**Town and Country Planning Act 1990 (as amended)  
S96a Application – Variation of condition 2 (approved plans) of 20/01511/MJR to allow for minor alterations to the previously approved development  
Adams Court and Bailey’s Court, North Luton Place, Adamsdown  
Planning Portal reference PP-09408039**

On behalf of the applicant, Cardiff Council and United Welsh Housing Association, please find enclosed a Non-Material Amendment application in respect of planning permission 20/01511/MJR. The fee of £115 associated with this submission, to be made by via the planning portal.

01 NEW FENCE + GATE 7 OUTSIDE PROPOSED RECEPTION 1:20  
 VIEWED FROM OUTSIDE

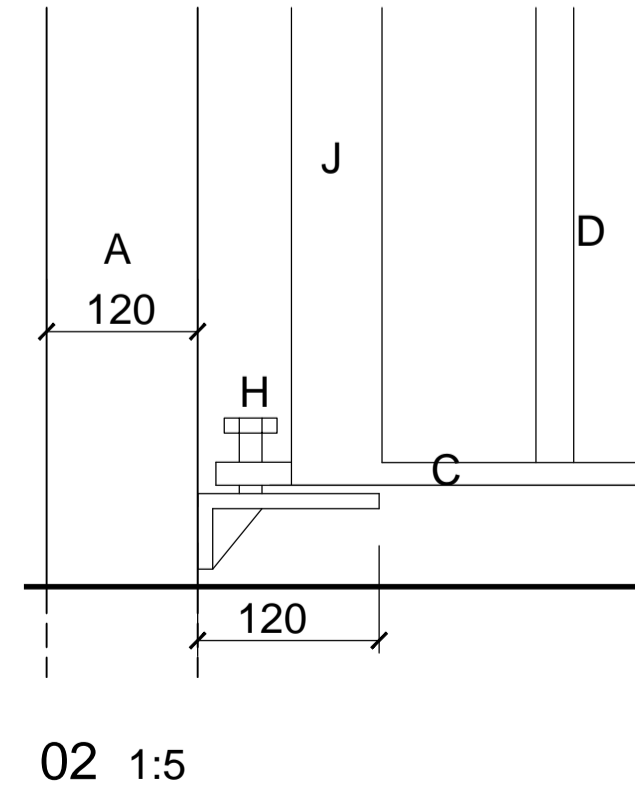
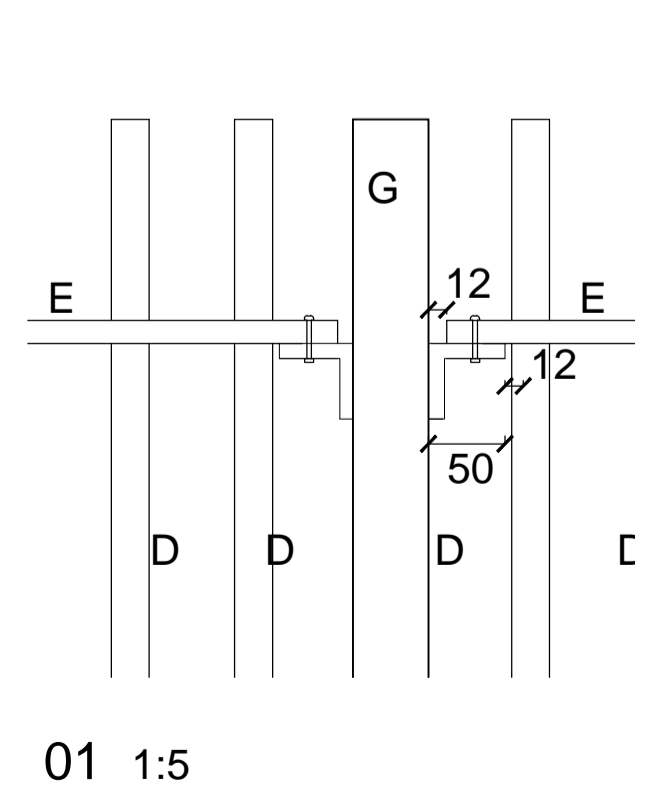
The proposed amendments concern the proposed boundary treatment around the entrance to Bailey Court to the south-west of the site, on the corner of Windsor Road and Moira Terrace. The approved boundary treatment is brick pillars between railings with dwarf brick wall below the railings. The applicant proposes 1.8m high fencing around the entrance to Bailey Court to match existing fencing, including a matching gate fitted with electronic lock to be connected to access control coupled with audio/visual facility. It will be fob operated.

The reason for the amendment is that upon starting groundwork for the brick wall, the contractor unearthed an array of services that crossed where the boundary treatment is proposed. Below ground services identified include fibre optics, phone lines and others (see appendix 1) rendering brick boundary treatment unviable. However, a boundary treatment is required to in order to increase security and safety at the site. Therefore, a railing is proposed instead of having to revert back to the existing situation which would prove inadequate to serve the proposed development. The low-level shrubs and paving proposed as part of the initial proposals are retained.
